S.J. Lawrence Architect Incorporated

Attention: Siobhan Kelly, Planner I, Development Review – City of Ottawa
Re: **Phase III – Pre-Consultation**
100 Bill Leathem Drive, Ottawa, ON
S.J.L Ref. No. SL_1117_24 Continental Flooring

Application Submission

Pre-Application Consultation: Meeting Feedback dated March 22nd, 2024

SHEET TITLE: SITE PLAN

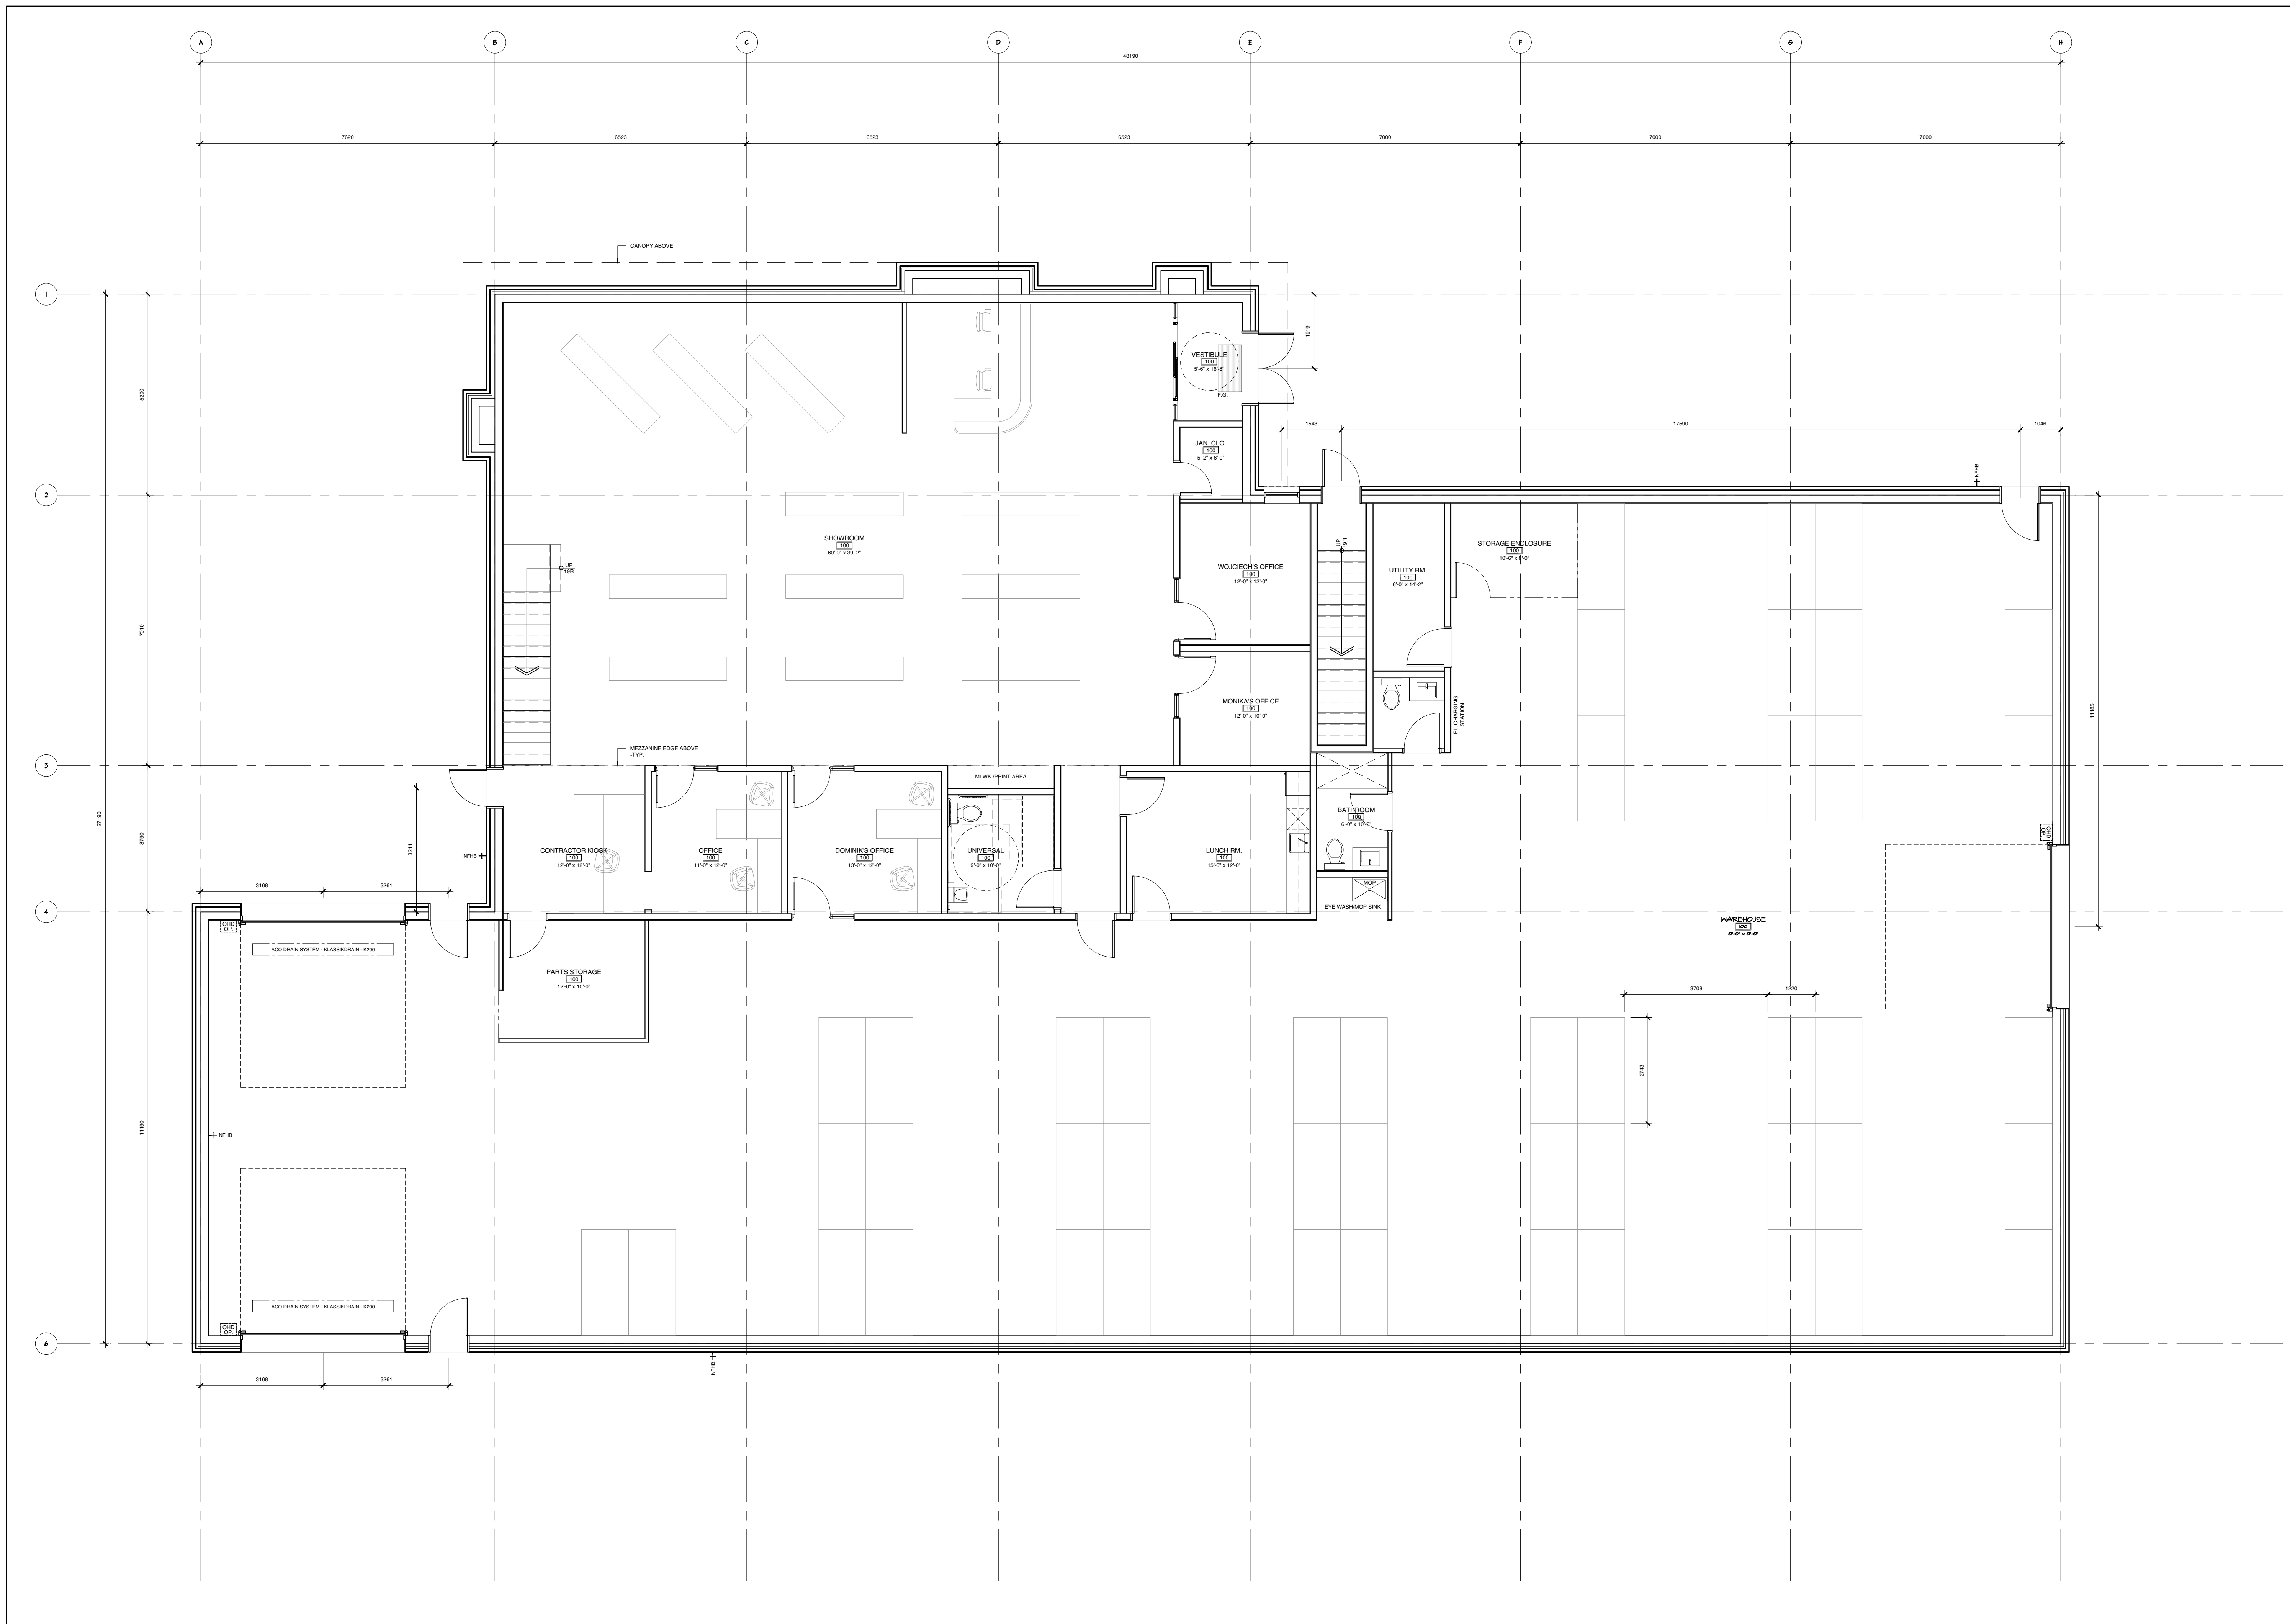
Pre-Consultation: Review Feedback dated June 27th, 2024

Comment No.02: Walkway leading to Clark Bellinger SWM Facility has been removed. Refer to revised Architectural and Landscape site plan.

Comment No.03: Chain-link fence has been added along rear property line. Refer to revised Architectural and Landscape site plan.

Comment No.34: Right of Way protection dimension has been added to Architectural site plan.
